# CITY OF ALBUQUERQUE

March 23, 2023

**Re: McDonald**  
**1901 Ladera Dr. NW**  
**Traffic Circulation Layout**  
Engineer's Stamp 02-16-23 (H09-D020)

TRAFFIC CIRCULATION
LAYOUT APPROVED

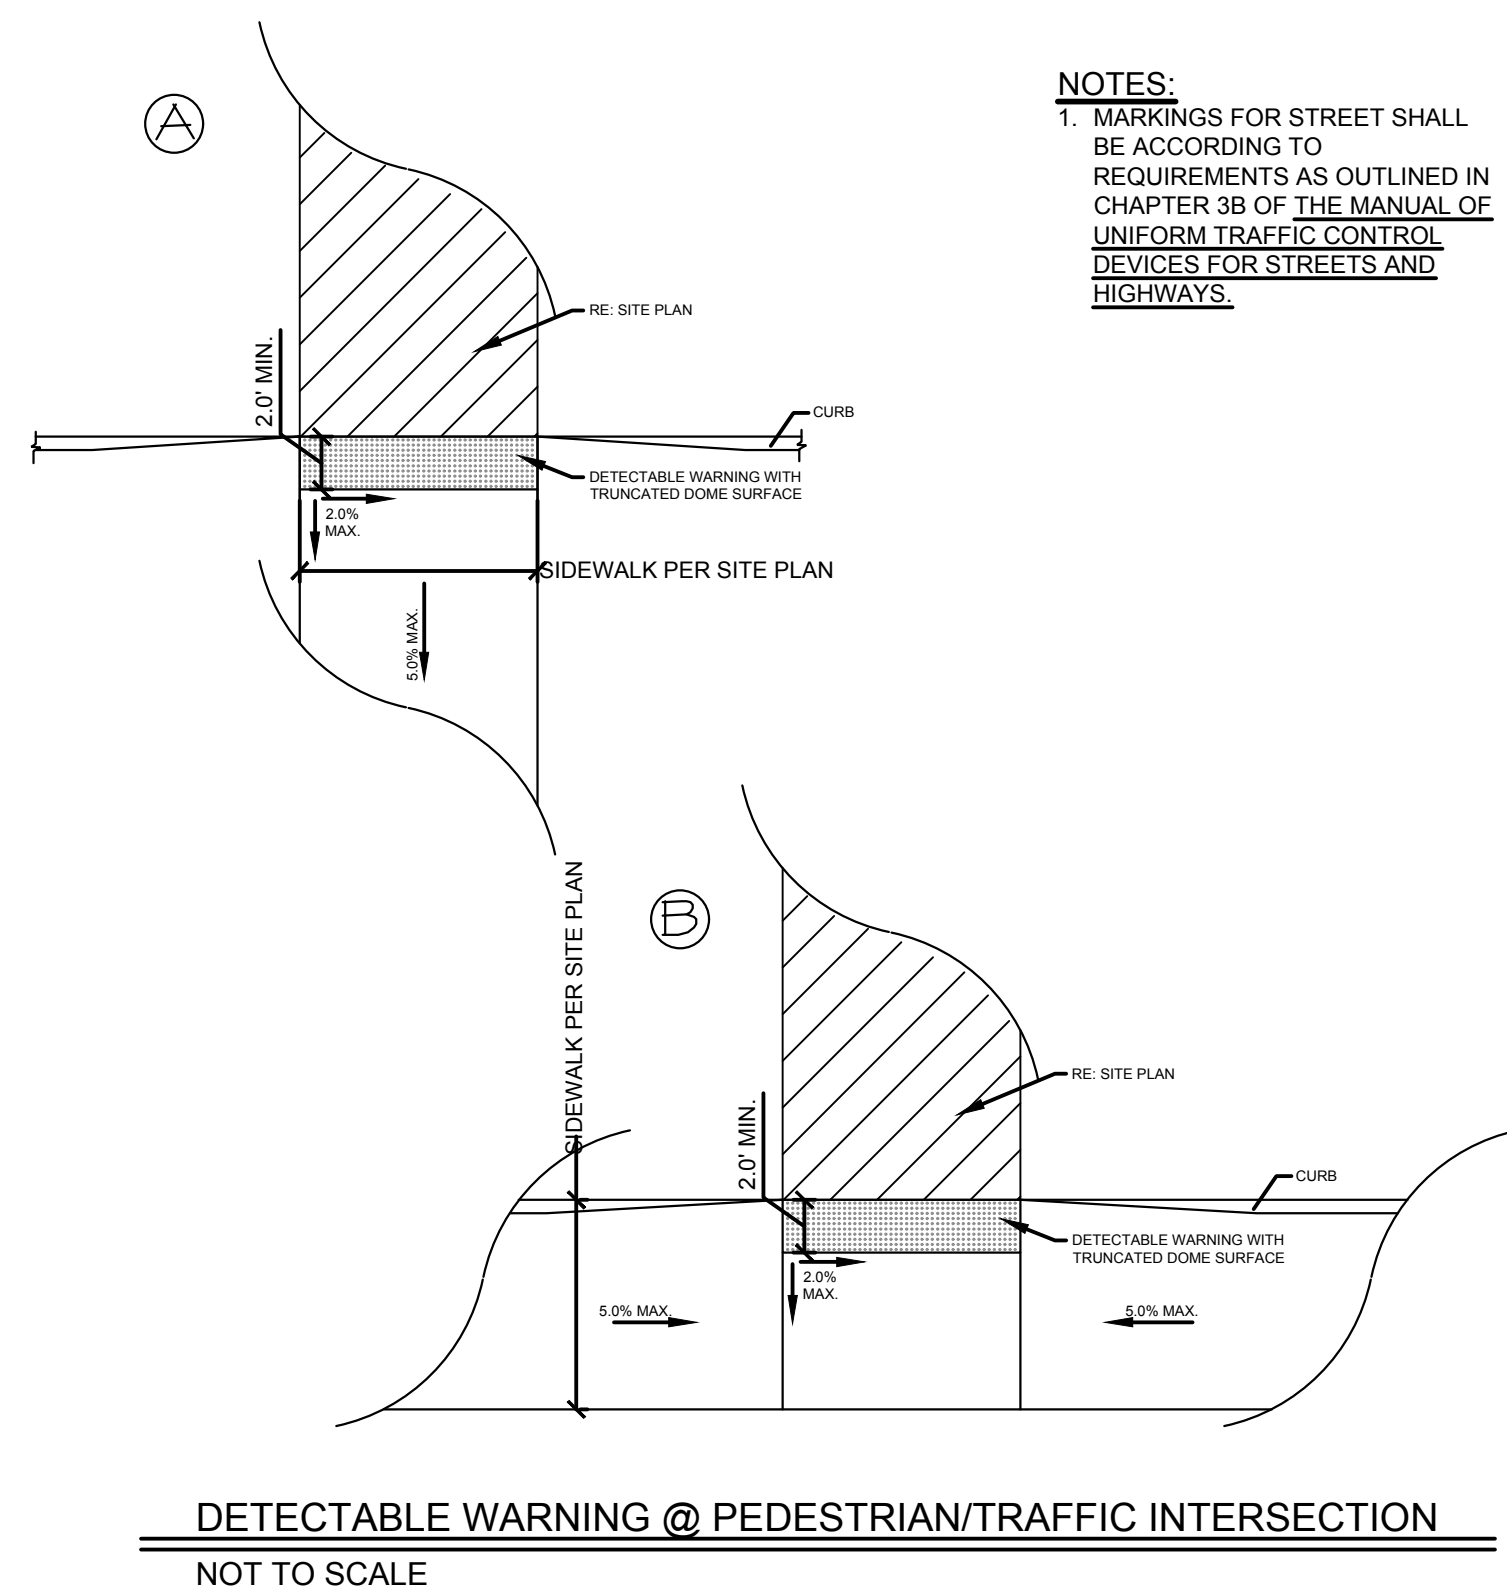
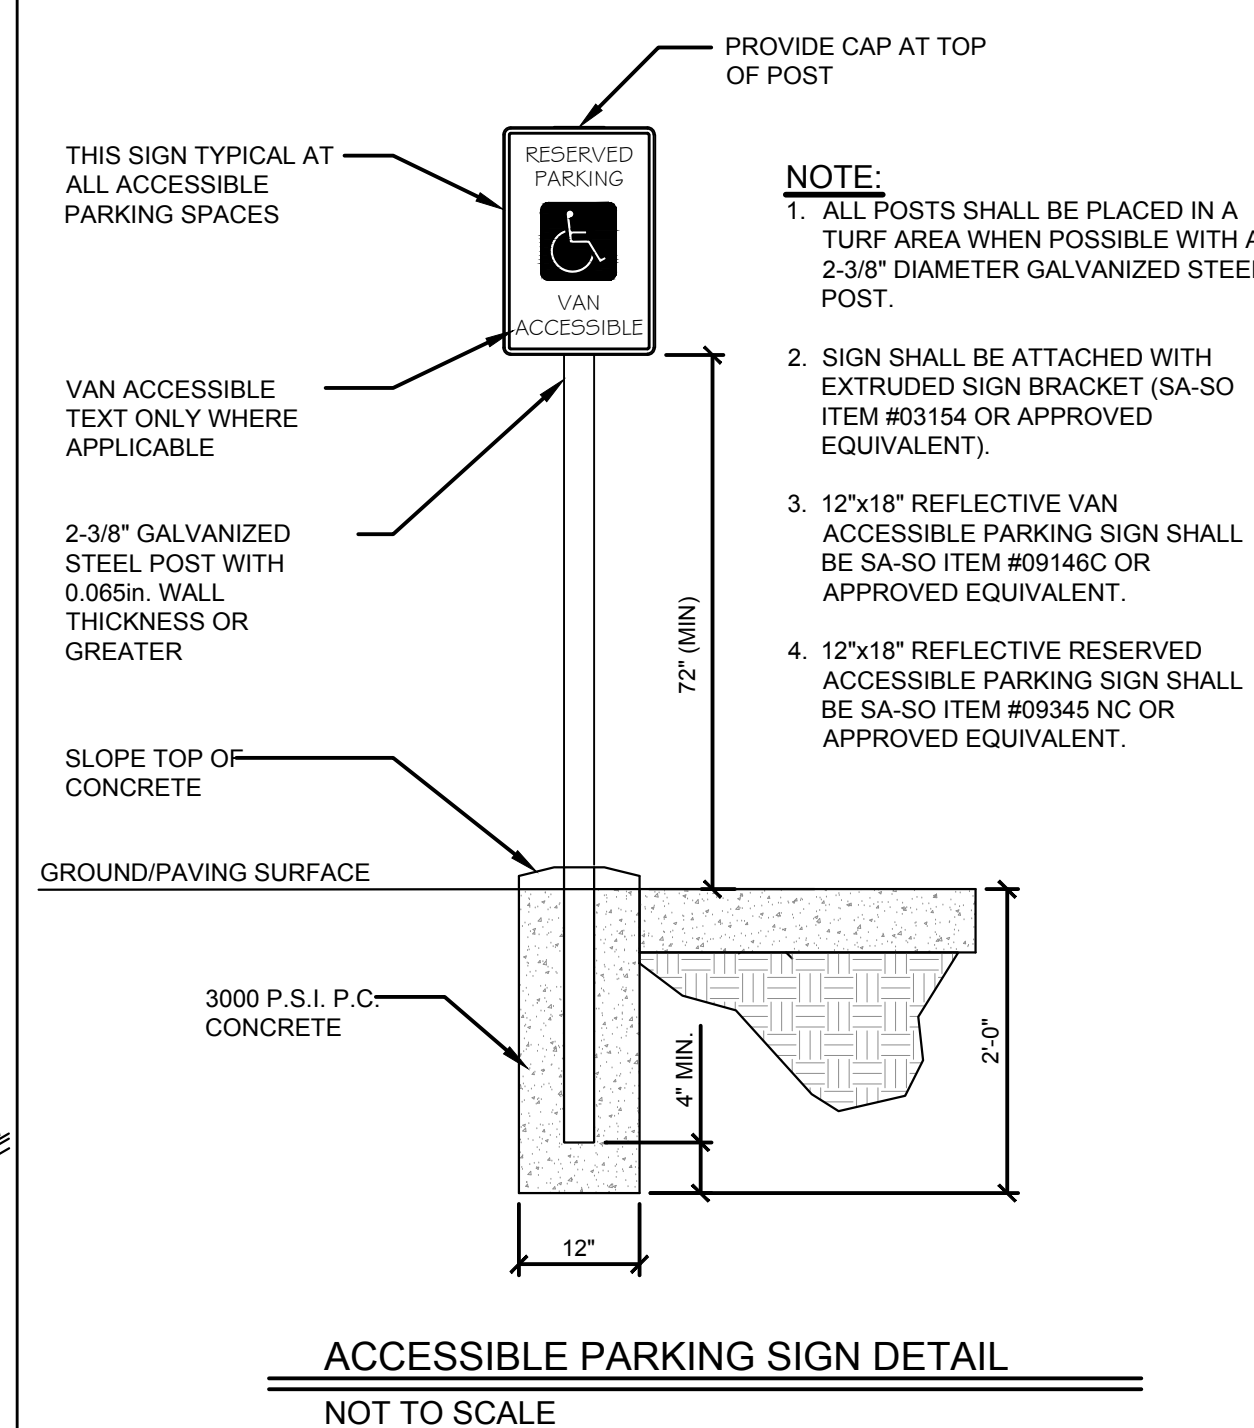
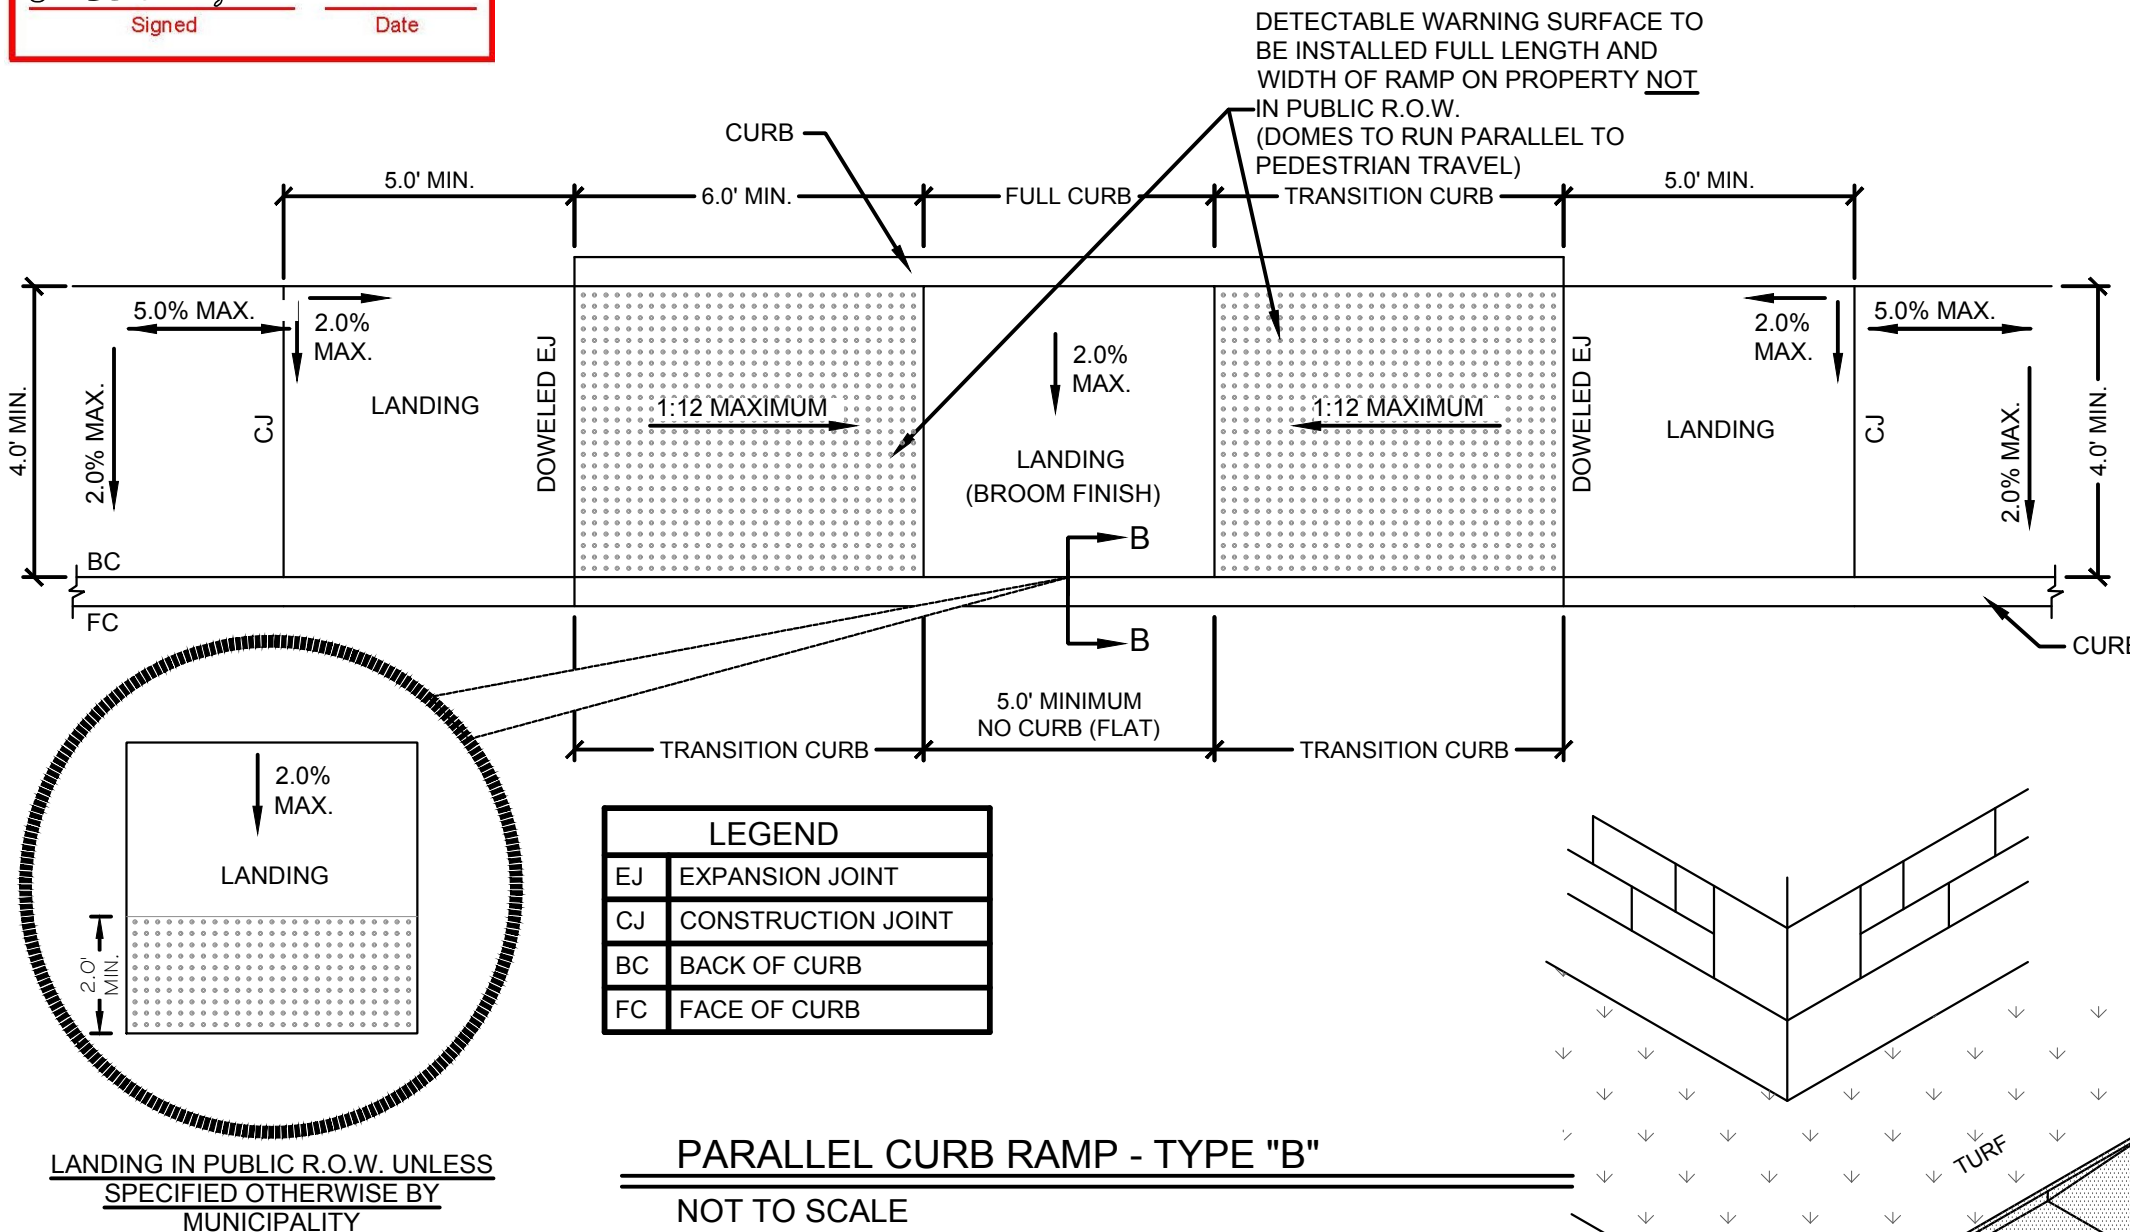
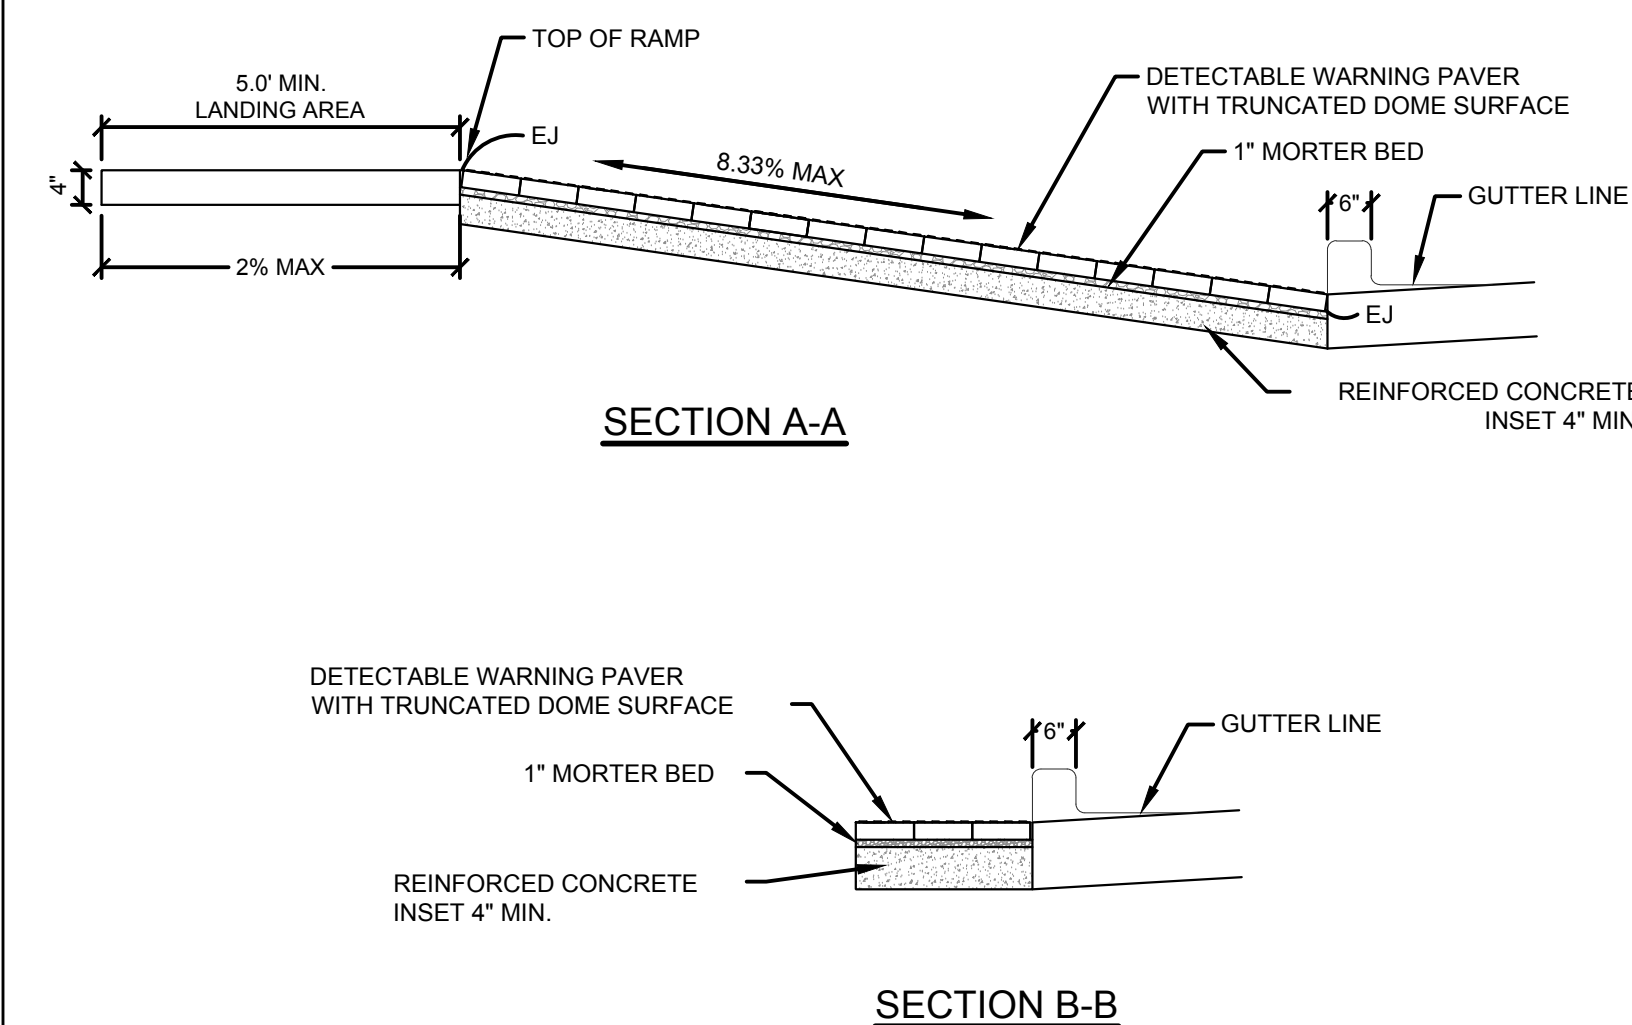
1. List the number of Bicycle parking spaces required by the IDO. Please show it on the site plan on the parking calculation table. Please provide Bike Racks details.

2. Please revised the dimensions for the proposed angled parking at the north side of the site. See attached dimensions or angle parking.
3. Please provide the dimensions for the Intersection clear sight triangle and add the following note to the plan: "Landscaping and signage will not interfere with clear sight requirements. Therefore, signs, walls, trees, and shrubbery between 3 and 8 feet tall (as measured from the gutter pan) will not be acceptable in the clear sight triangle.

4. Key note 30: in addition to the stop sign, please provide "STOP" & "DO NOT ENTER" pavement marking.
5. Please provide coy of Fire Marshal and Solid Waste approval.

6. It is not apparent what type of pavement surface is being proposed. A hard driving surface will be required as part of this proposed project for parking area and drive aisles.

7. Please specify the City Standard Drawing Number when applicable.
8. Add a note stating "All broken or cracked sidewalk must be replaced with sidewalk and curb & gutter." A build note must be provided referring to the appropriate City Standard drawing.
